North Mayo Hillwalkers
Carrowkeel, Kincon, Ballina, Co Mayo
mariongalt@gmail.com

RE: Proposed Tirawley Wind Farm - PAX16.324258

The North Mayo Hillwalkers formally opposes the proposed Tirawley Wind-farm Strategic Infrastructure Development as detailed above.

Plate 12.8: Zone of Theoretic Visibility Map (ZTV) based on bare-ground data showing the full extent of the 20km study area.

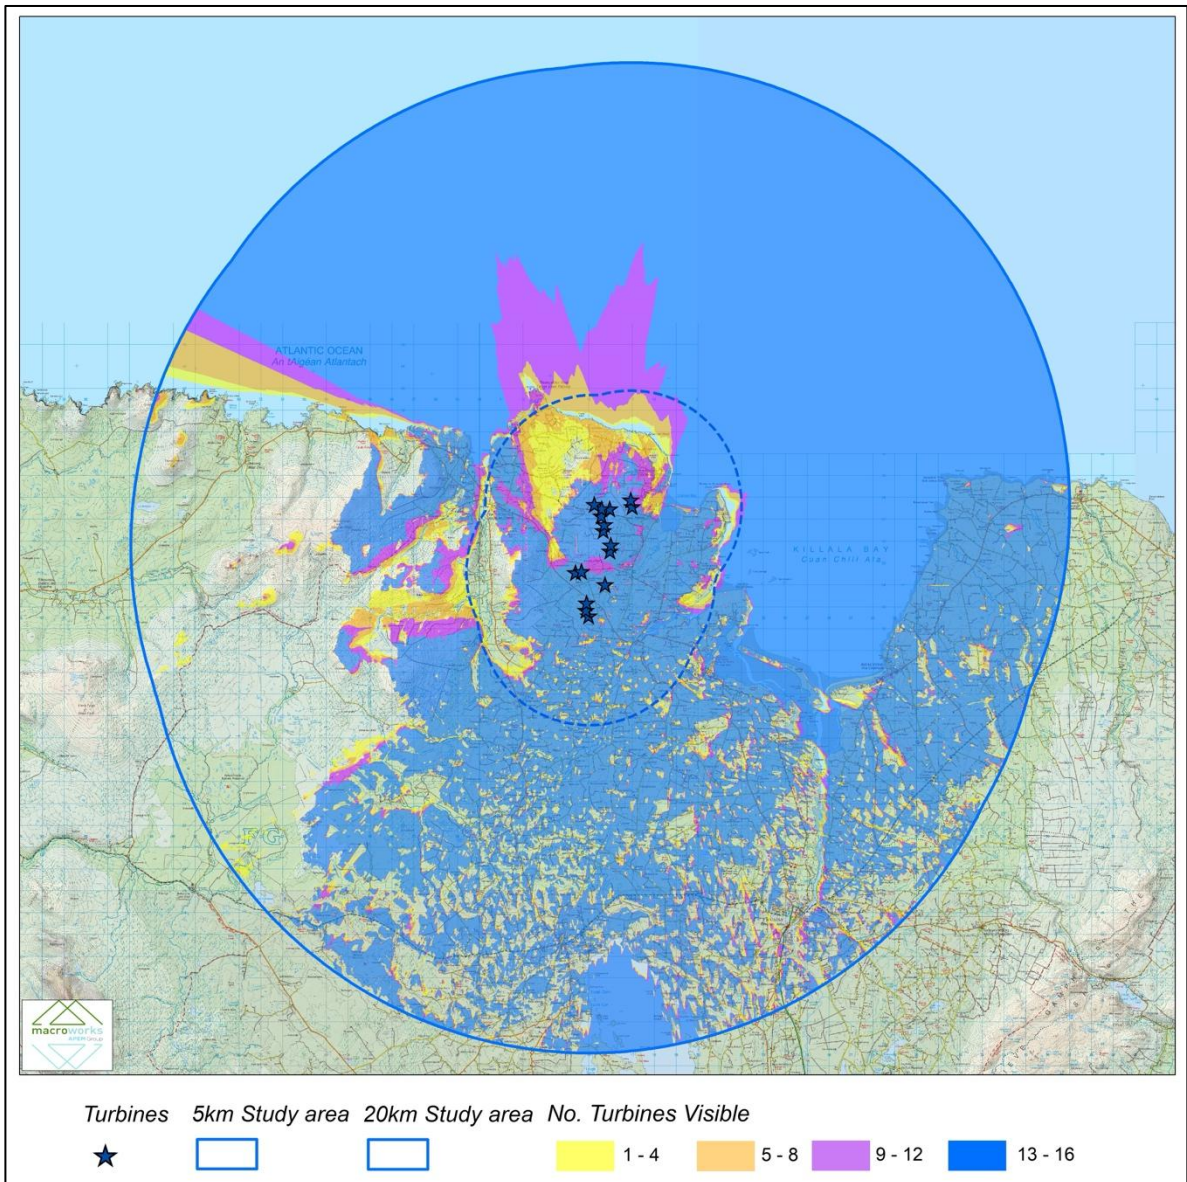
For instance, according to the EIAR's ZTV mapping there is potential visibility of nine turbines from Downpatrick Head. This is possibly the area's most

Plate 12.10: Cumulative ZTV Map (Tip Height -135m) for Tirawley Wind Farm identifying the potential intervisibility of the proposed Wind Farm and all other existing and consented wind farms within the study area (See Volume III Figure 12.10 for larger version).

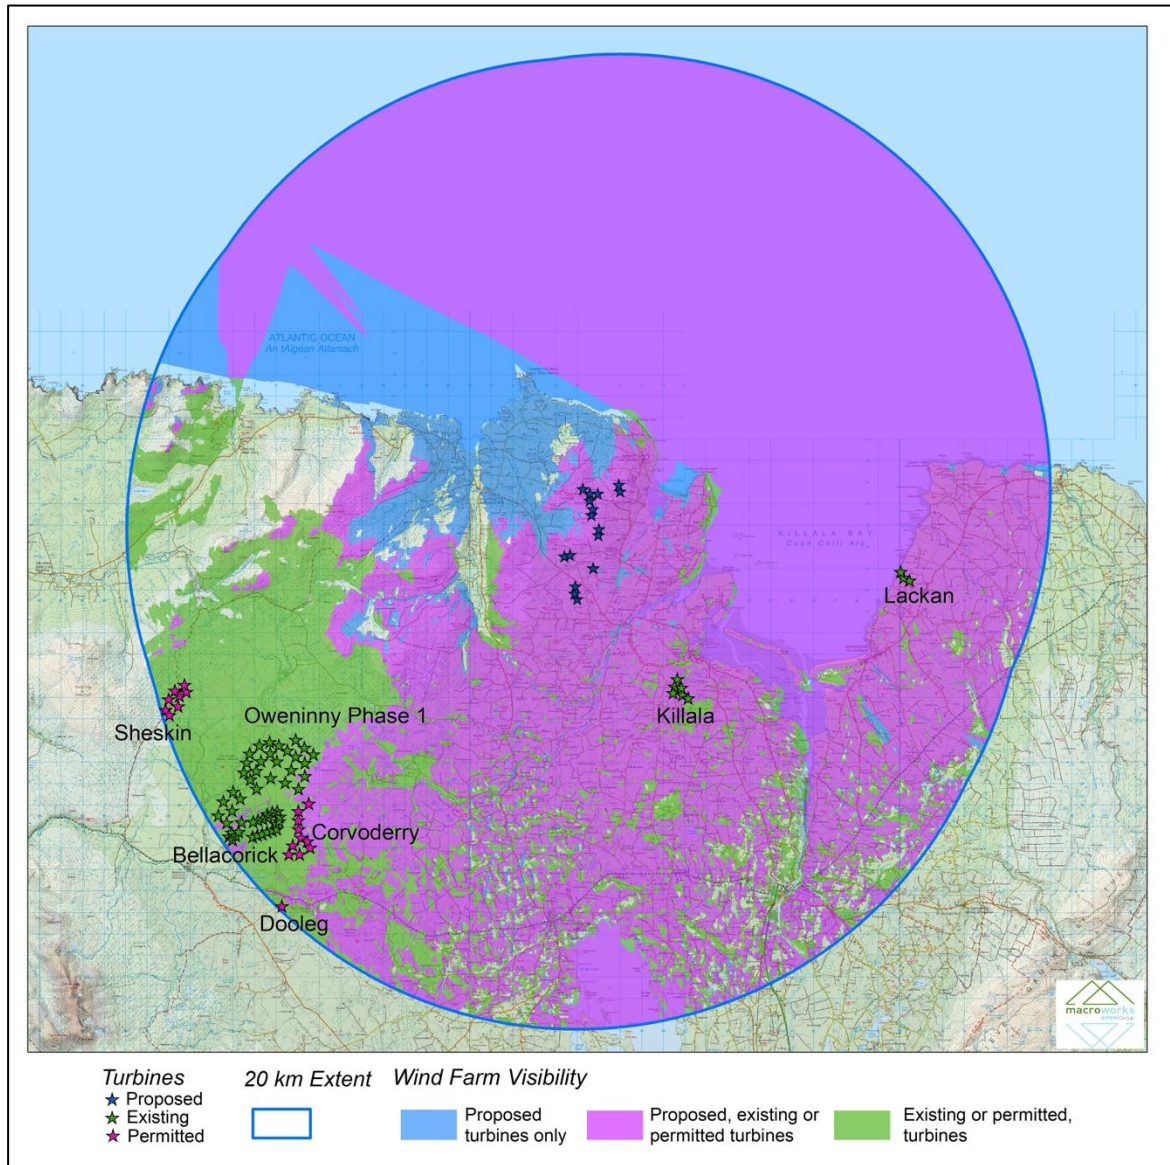
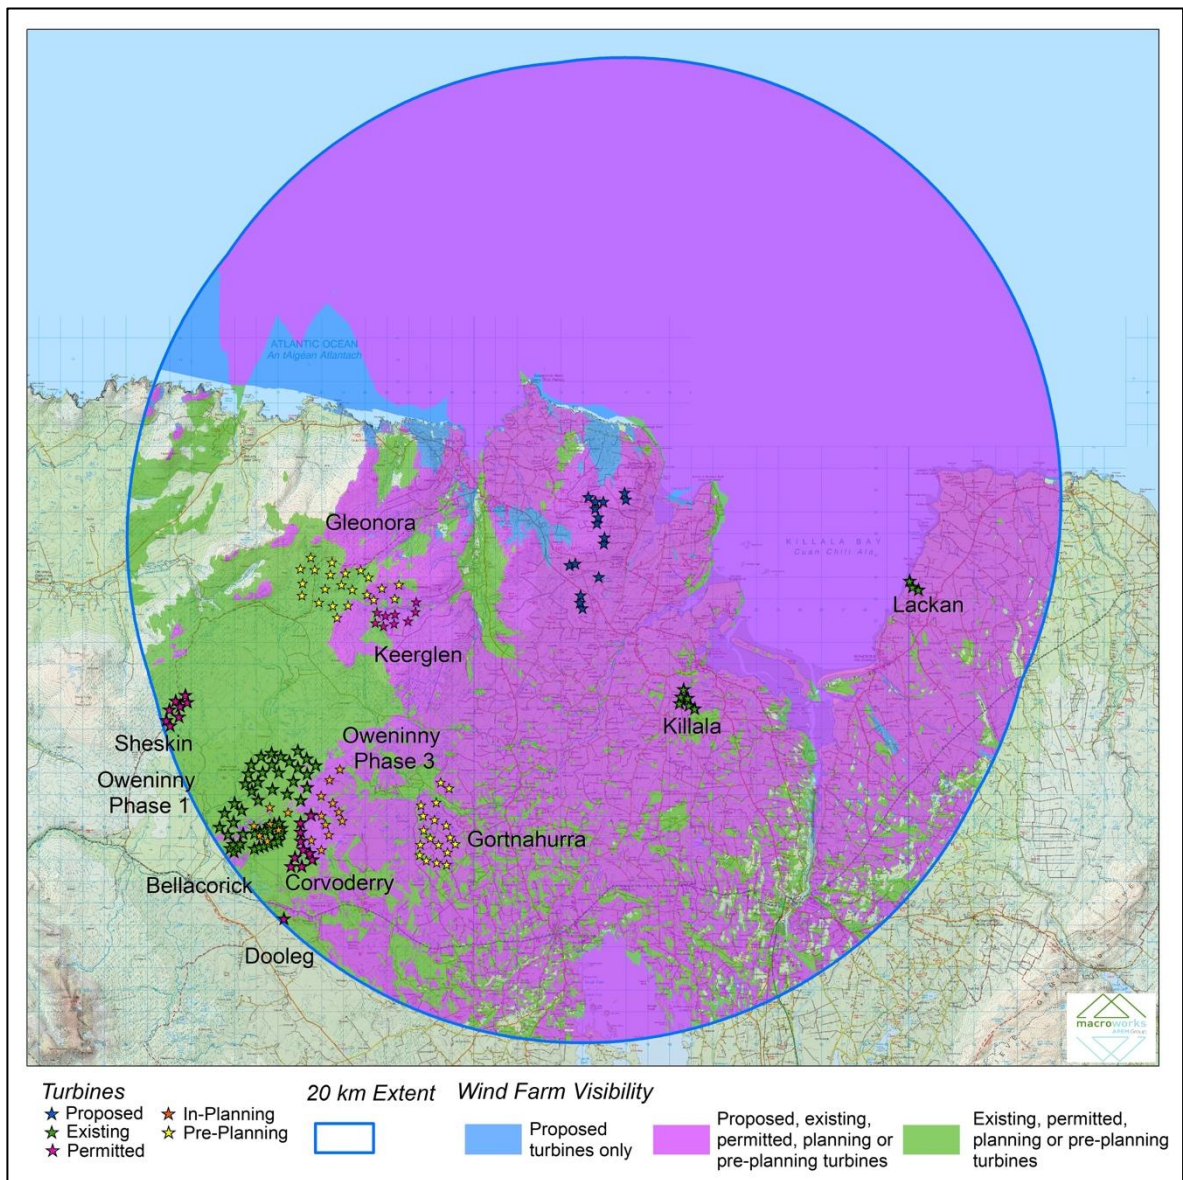
Turbine visibility from the many walking routes of the area may have been underestimated in the EIAR. In addition to the Tirawley windfarm, multiple other windfarm projects are planned in the wider area (Glenora, Keerglen, Clydagh, Aries, etc). The cumulative effect of these will mean that many walking route are likely to include turbine visibility from many angles.

As well as Tirawley's 16-turbine project, other nearby windfarm projects in the area include: Glenora (22 turbines, 6.5 kilometres distance to Tirawley); Keerglen (8 turbines, 6k away); Clydagh (22 turbines, 3k away); Aries (11 turbines, 18k away).

Although each of these windfarm projects is judged in isolation, residents and visitors experience the area as a whole; its landscape, its tranquility (or otherwise); its flora and fauna. To fully assess this project, it should be looked at in the context of the many other nearby windfarms - whether granted, planned or yet to come.
